I set out below the Town Council's objection to this application.

APPLICATION AB/8/12/
NO:

Registered: 01-FEB-12
Site Land adj 84 Maltravers Street Aundel BN18 9DS
Address:

Description of Works: Erection of 1 no. new dwelling

Elevations & Section

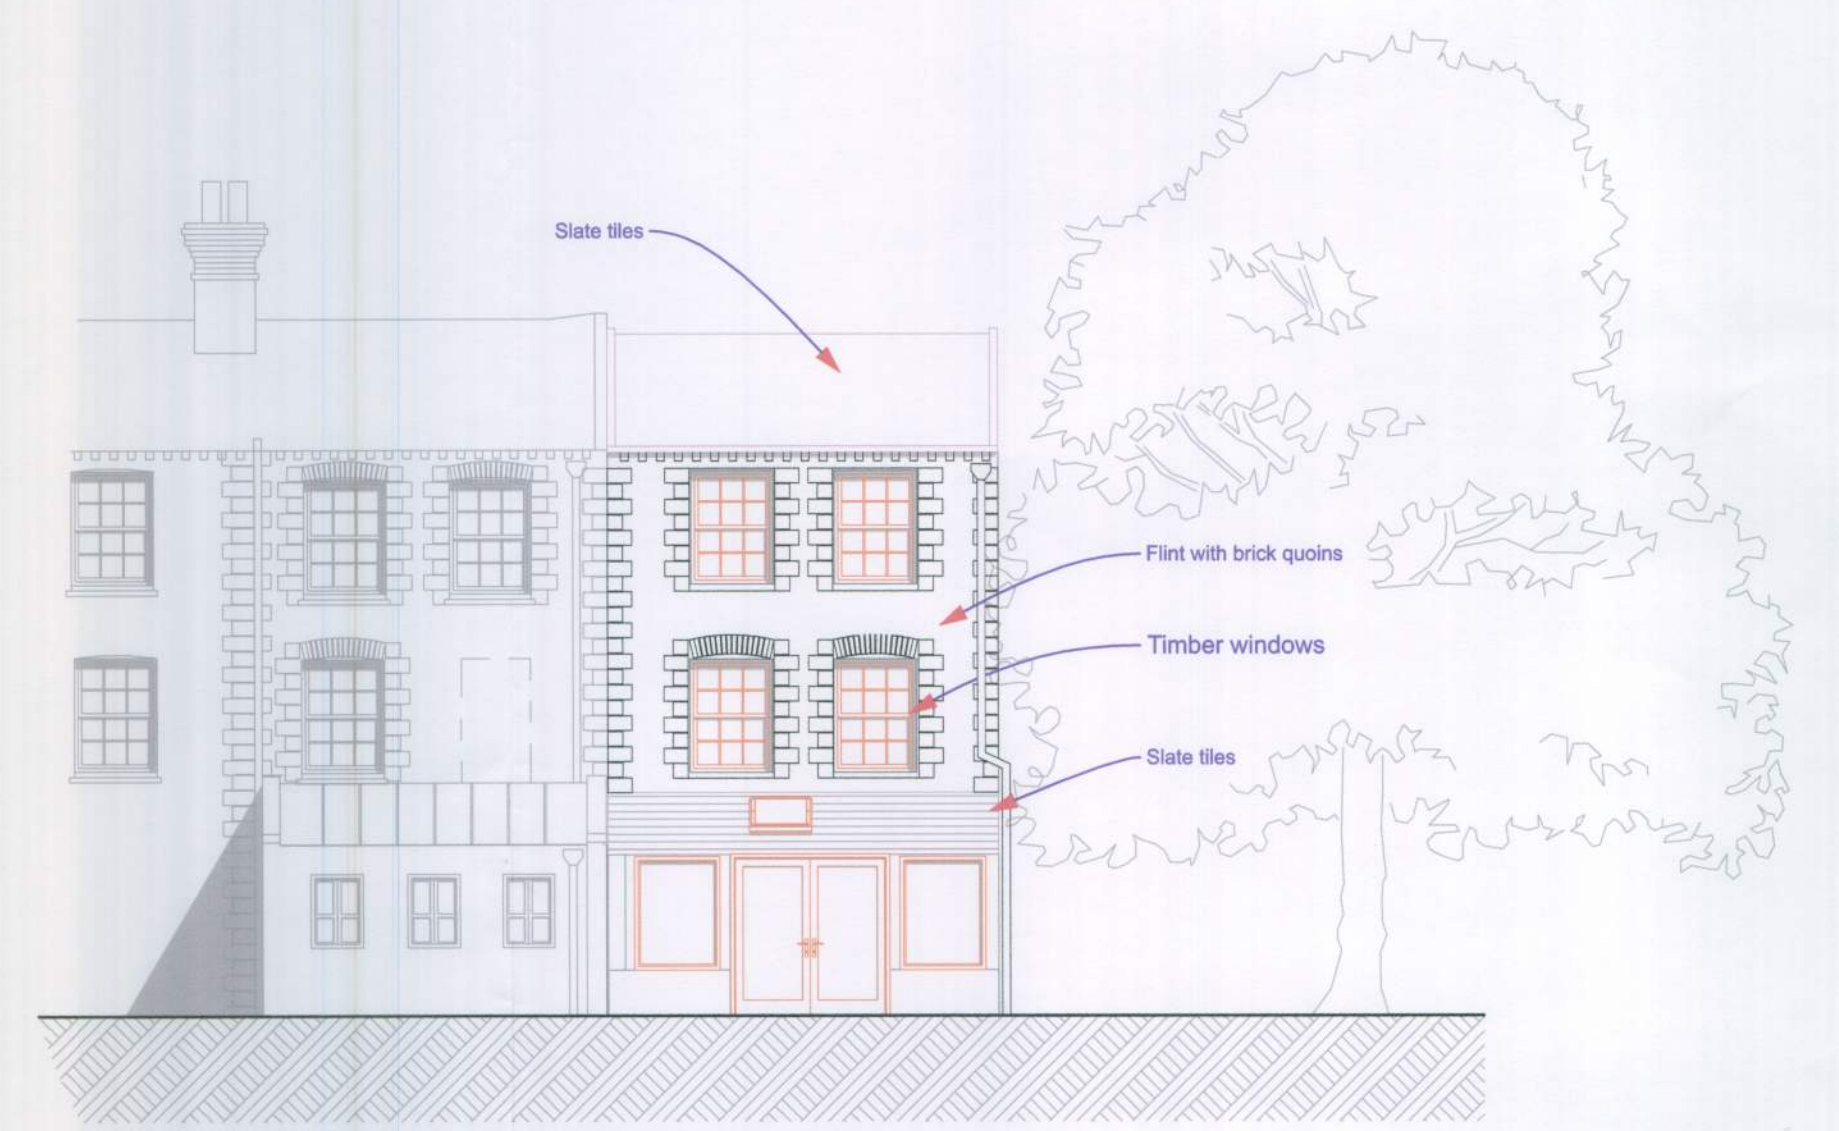
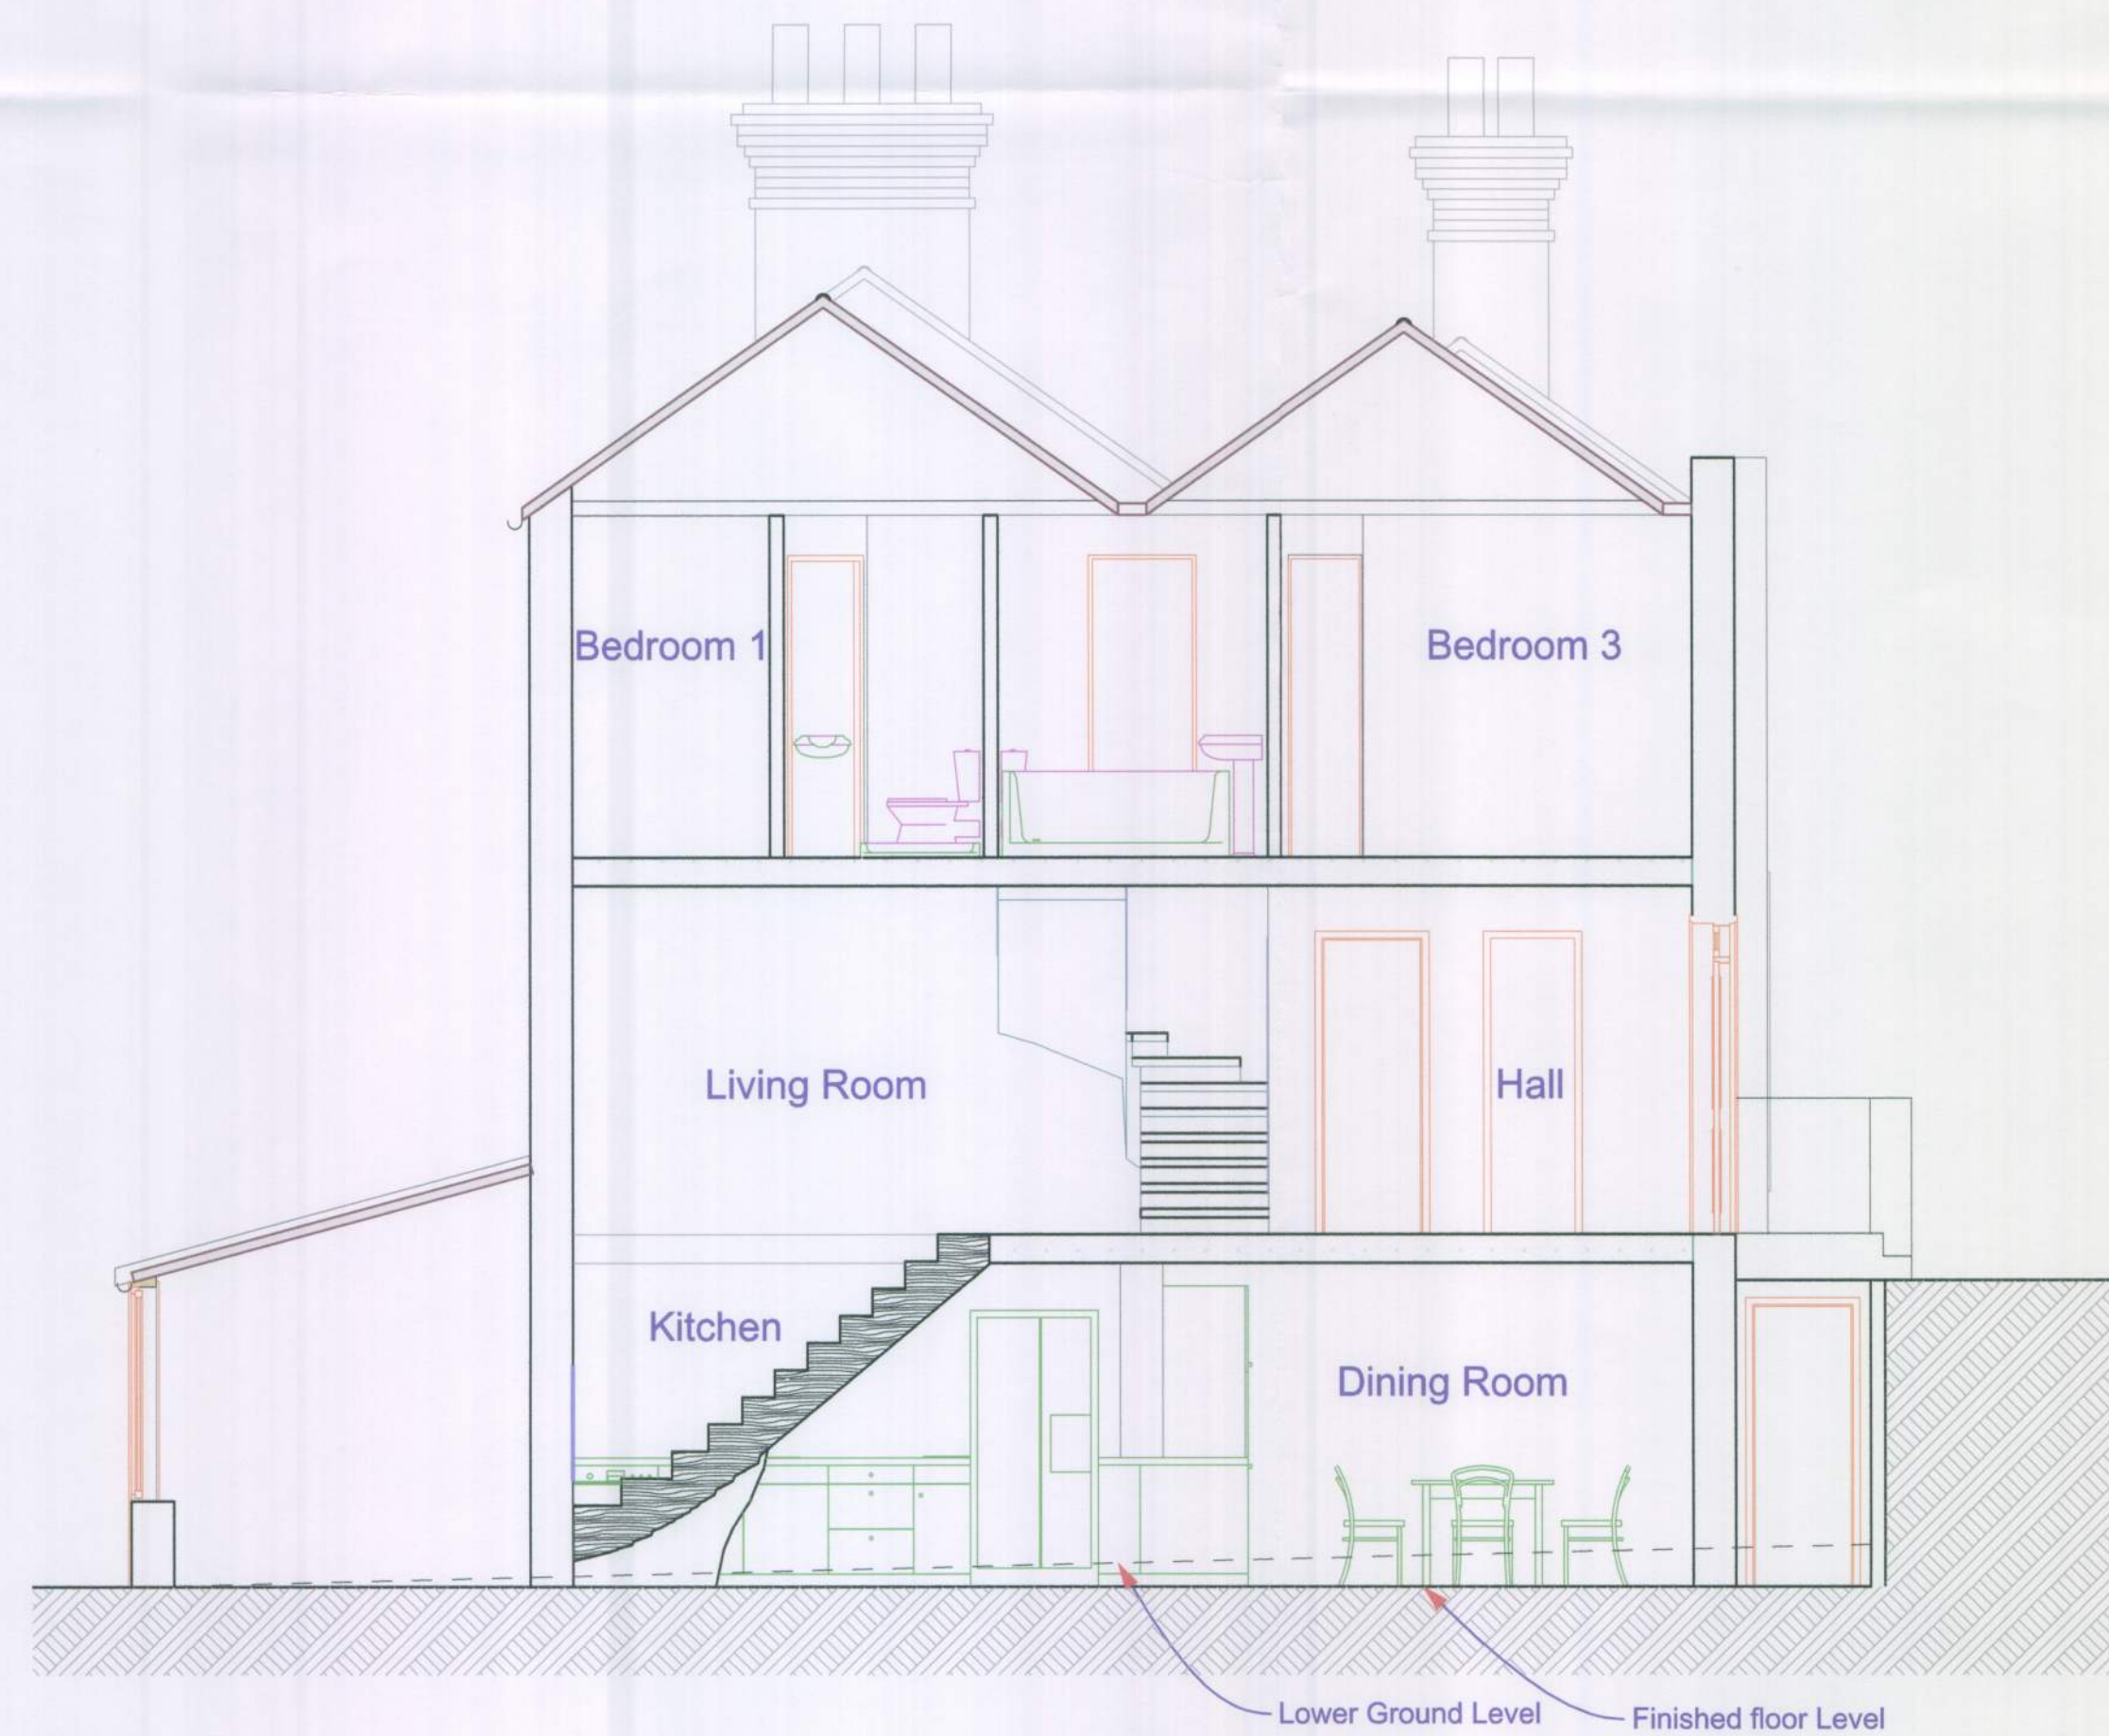
The Committee objected to the application on the grounds that the proposal would appear as a modern addition that would fail to respect and sympathise with the integrity and appearance of this listed row of terraced properties. It would therefore harmfully detract from the character and appearance of the row of terraced properties and this prominent part of the street scene. The scheme also provides no off street parking and would unacceptably exacerbate the existing demand for the limited spaces in the car parking bays to the front of the terrace
